Ref. 23296.

4th March 2024.

Re: ABP – 318505-23. Carrownagowan 110kV Grid Connection - Futureenergy Carrownagowan Designated Activity Company (DAC)

Reinstatement details based on Guidelines for Managing Openings in Public Roads - SD2

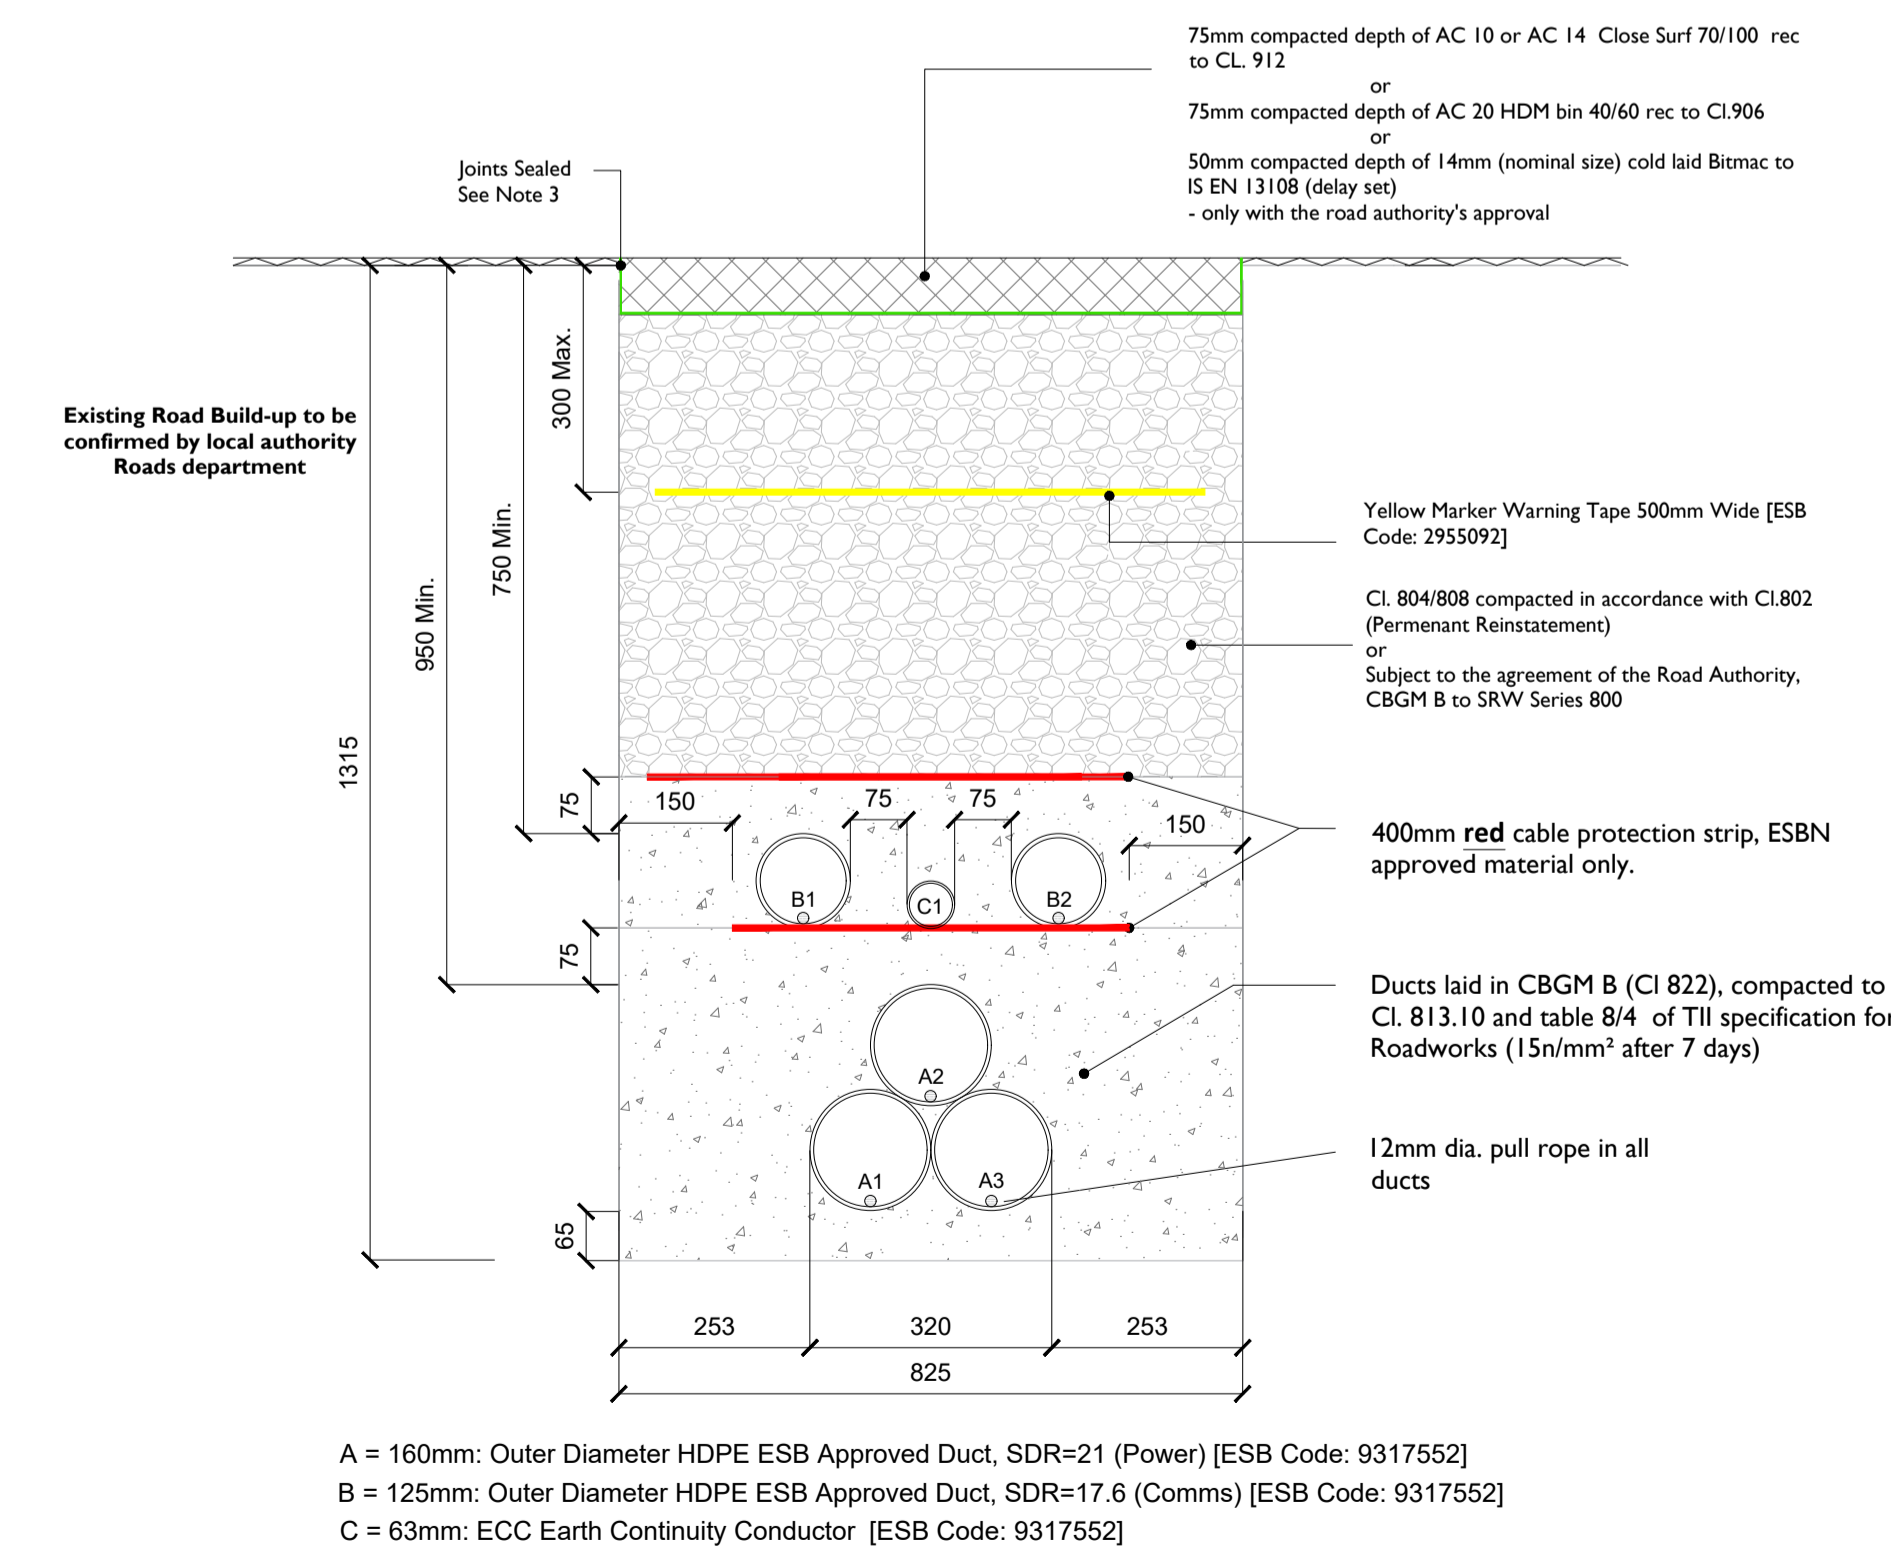
The materials used in construction of the grid route are shown on Drawing Number 05641-221 and 05641-222. The specification for materials is set out in the EIRGRID specifications for 110kV underground grid routes. The drawings referenced above show the sectional layout of the trench and shows the PVC ducts installed along with bedding and surround, protection tapes and finished road surfaces. The materials used do not include lead materials.
